Appeal Decision

Appeal Ref: APP/Z4718/D/24/3343749

2 Four Winds, Highbridge Lane, Skelmanthorpe, Kirklees, Huddersfield HD8 9JY

- The appeal is made under section 78 of the Town and Country Planning Act 1990 against a refusal to grant planning permission.
 - The appeal is made by Mr & Mrs N Hepworth against the decision of Kirklees Council.
 - The application reference is 2023/62/93664/E.
 - The development proposed is for the erection of extensions and alterations (modified proposal).
-

title **General Arrangement as Proposed**
number **22014D-03-P04**
scale **1:100 / 1:200**
size **A1**

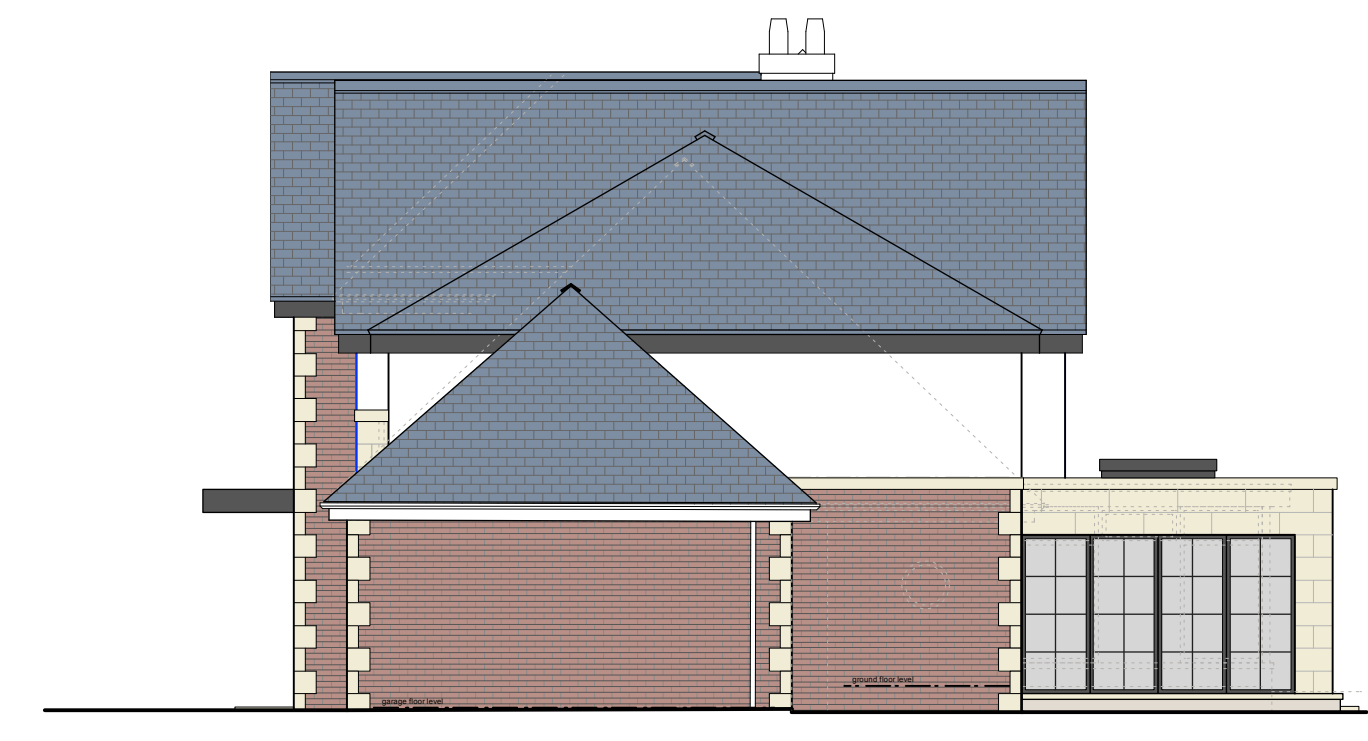
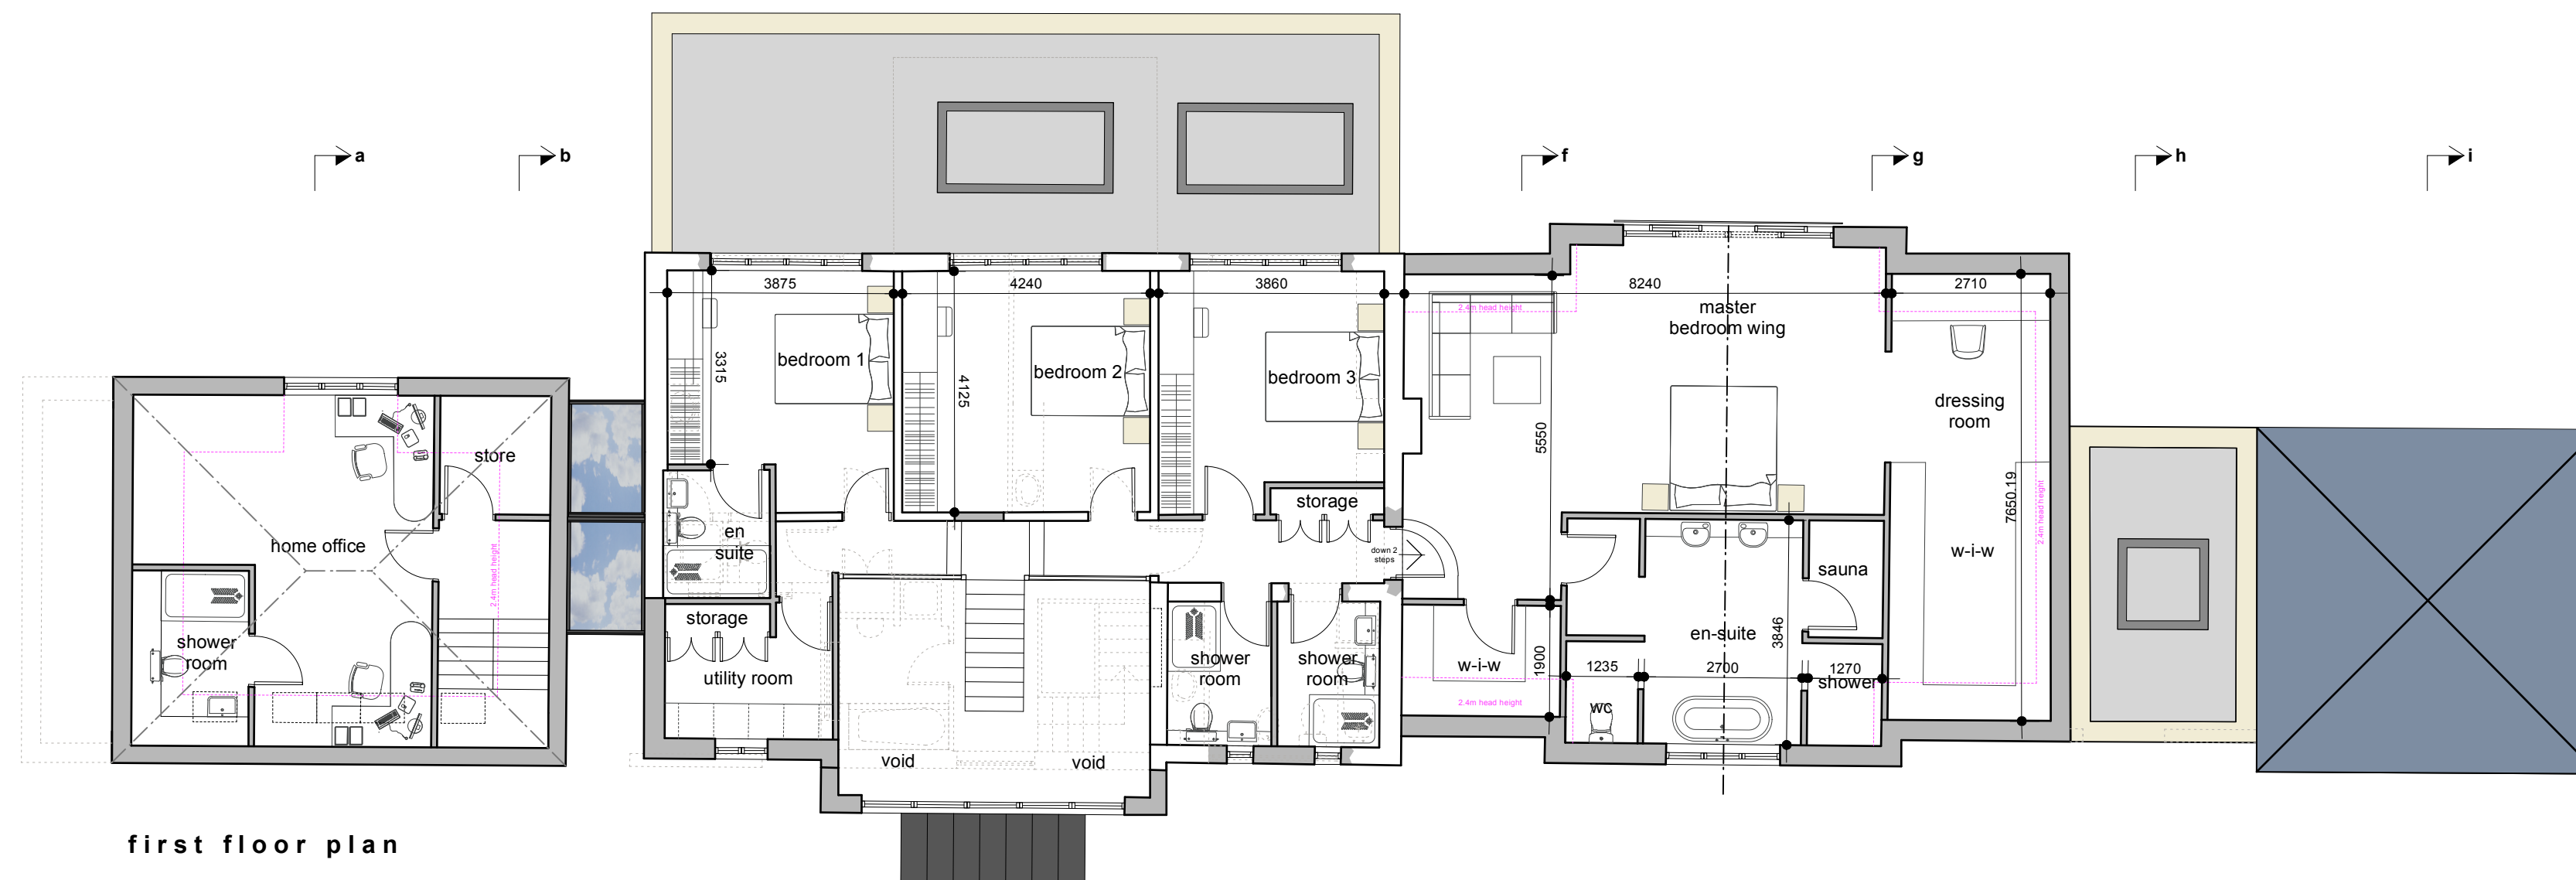
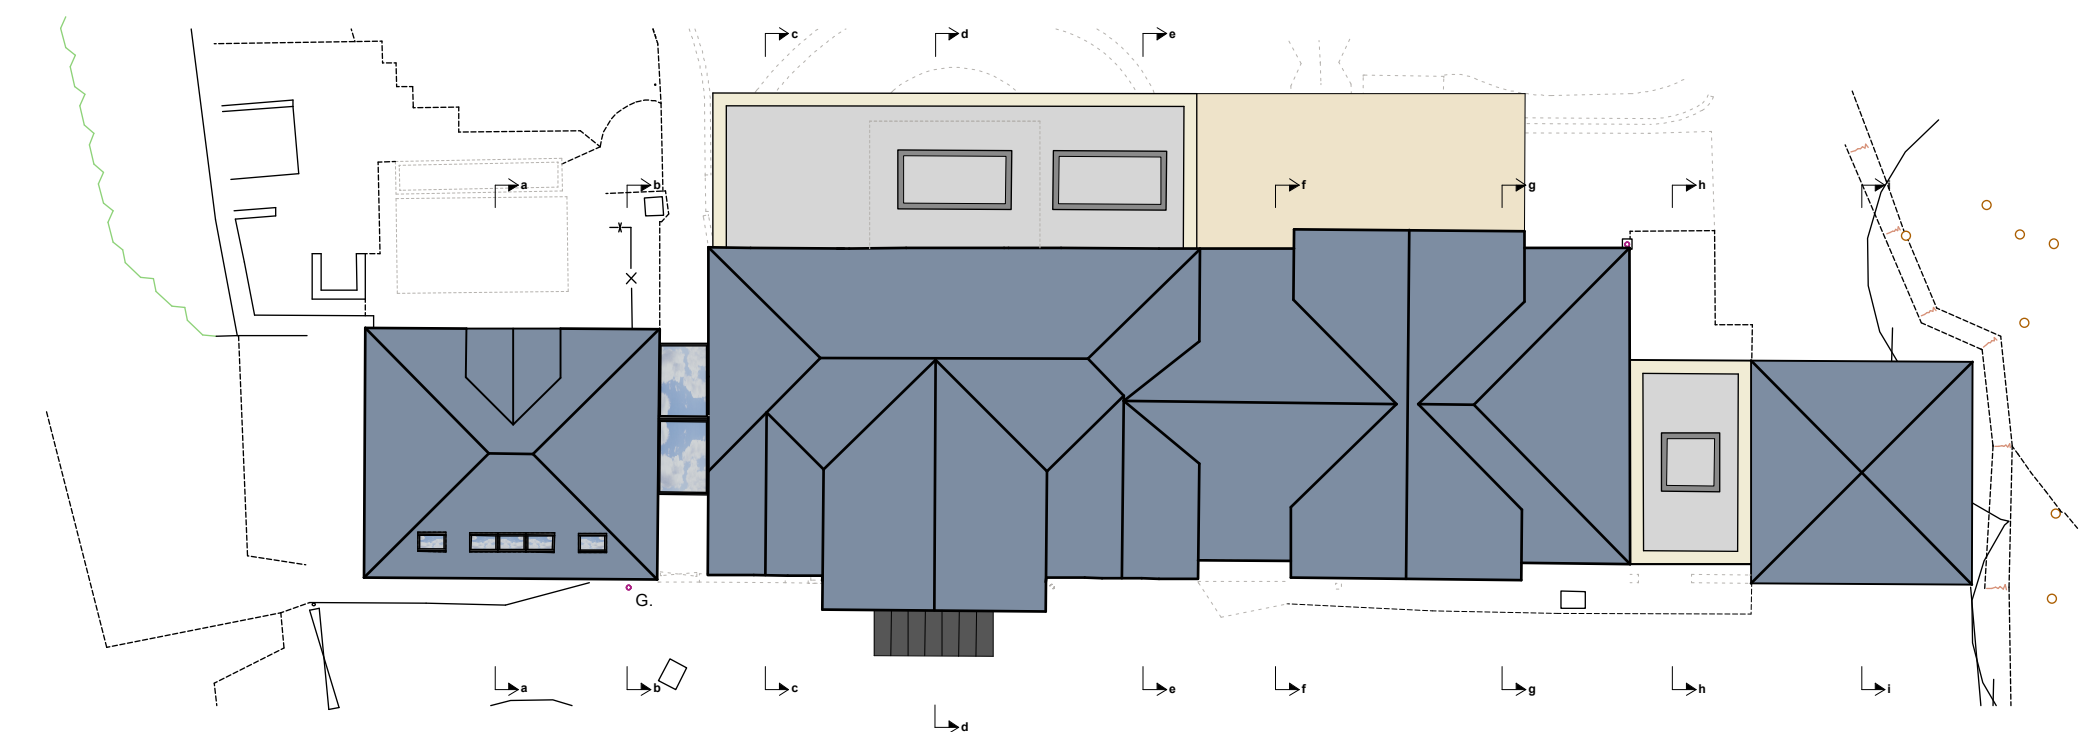
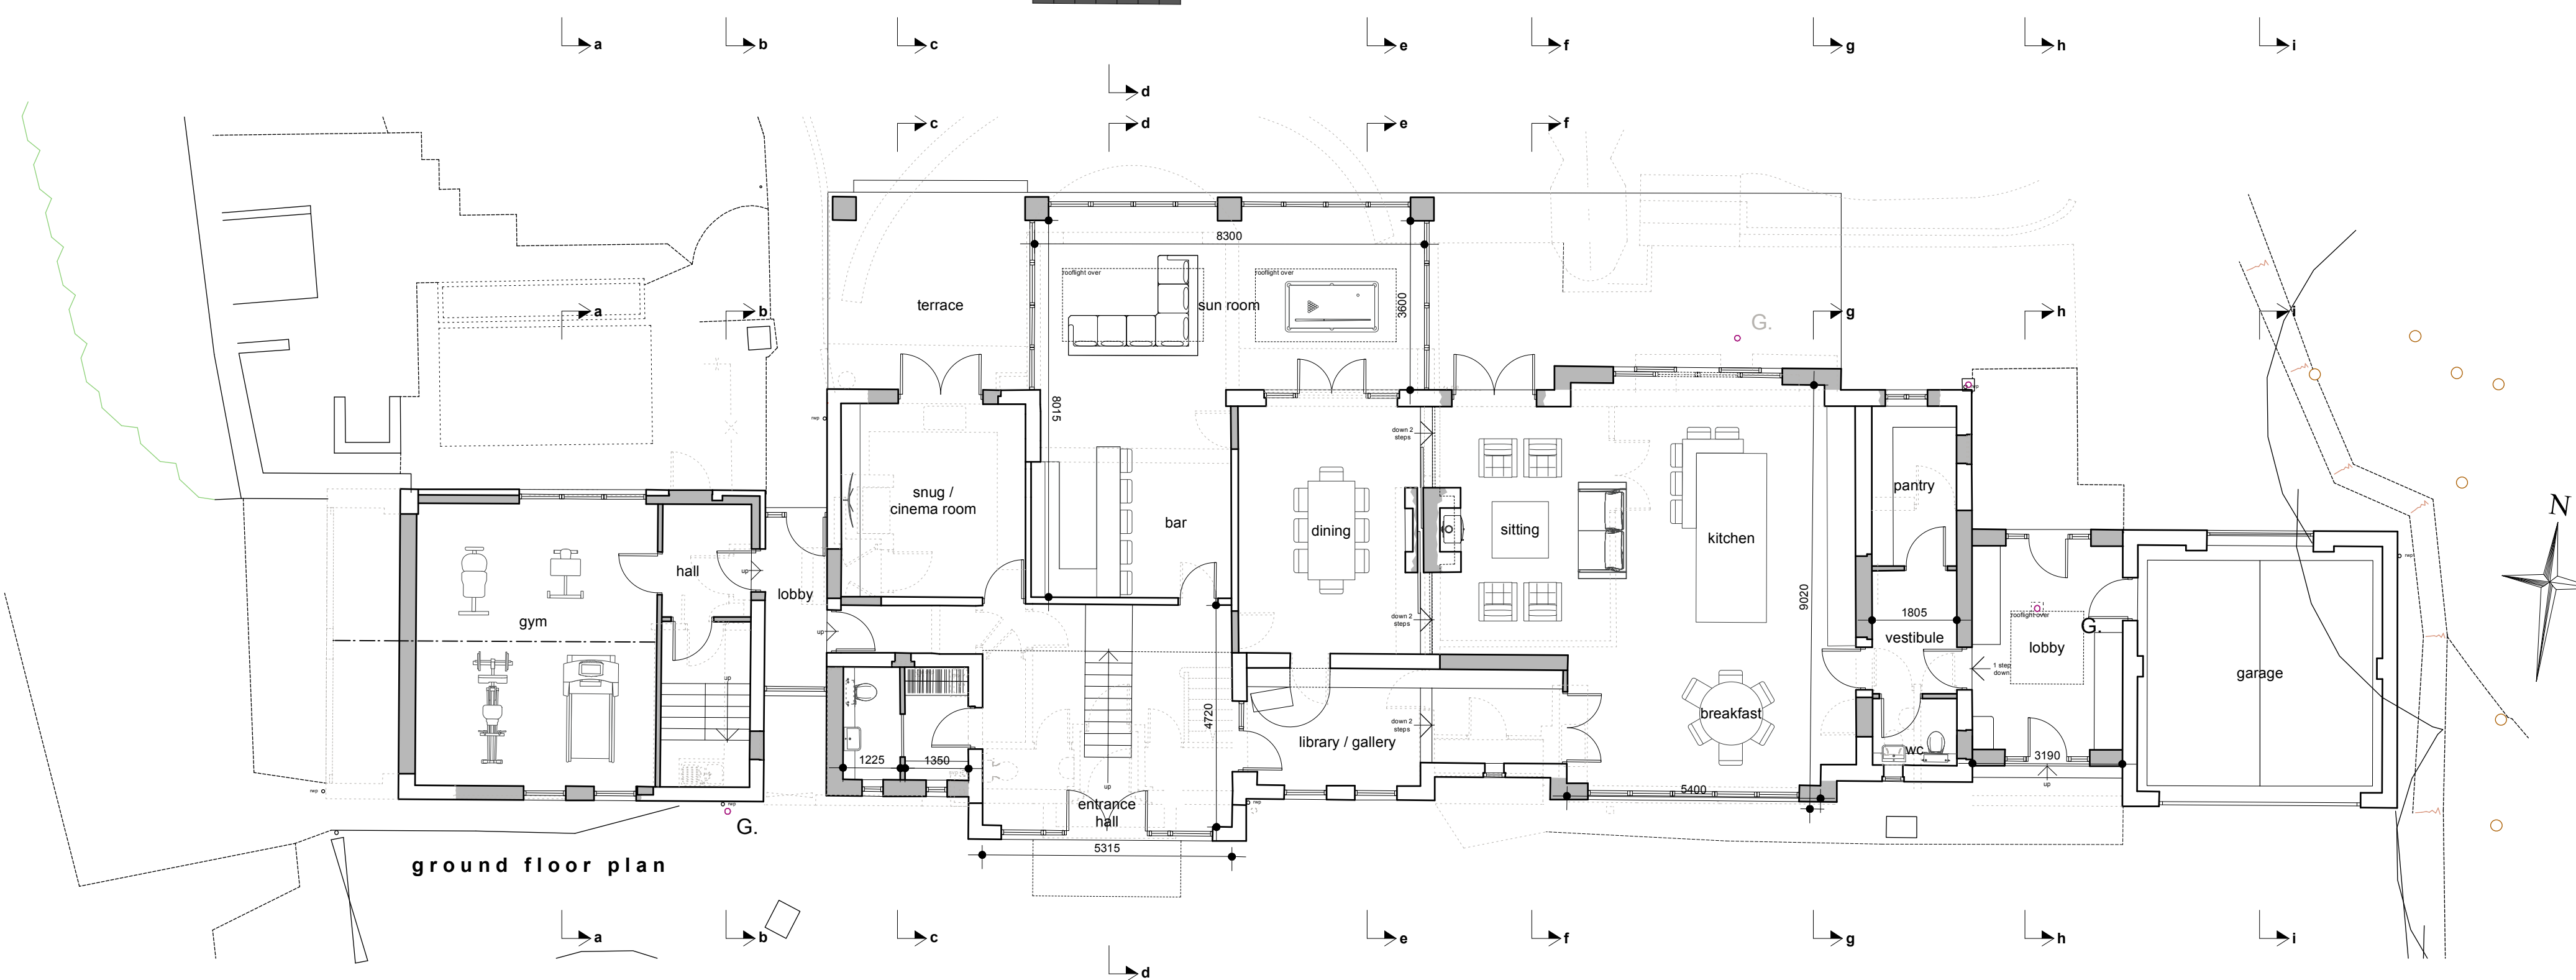
7. When considering whether the extensions are disproportionate compared to the original dwelling, it is necessary as part of the planning judgement to consider the scale, volume, bulk, massing and built form that would result from the changes sought. In this case, the proposed extensions, particularly the first-floor additions, would add substantial bulk and massing to the building, to the degree that the original building would not remain the dominant element in terms of size and overall appearance. Therefore, the proposal would result in a disproportionate and inappropriate addition, which according to paragraph 152 of the Framework is, by definition, harmful to the Green Belt.

proposed development, particularly due to the extensive alterations at the first-floor level, would significantly increase the massing, bulk, and overall volume of the host dwelling. Although the elongated plan form would remain, due to the overall scale of the extensions, the development would result in a dominant feature that would adversely affect the character and appearance of the host dwelling.

12. Consequently, given its significant scale, form, and siting in relation to the host dwelling, the proposal would fail to appear subordinate to it. Accordingly, the proposal would be contrary to Policies LP24 and LP57 of the LP and the advice in the SPD.
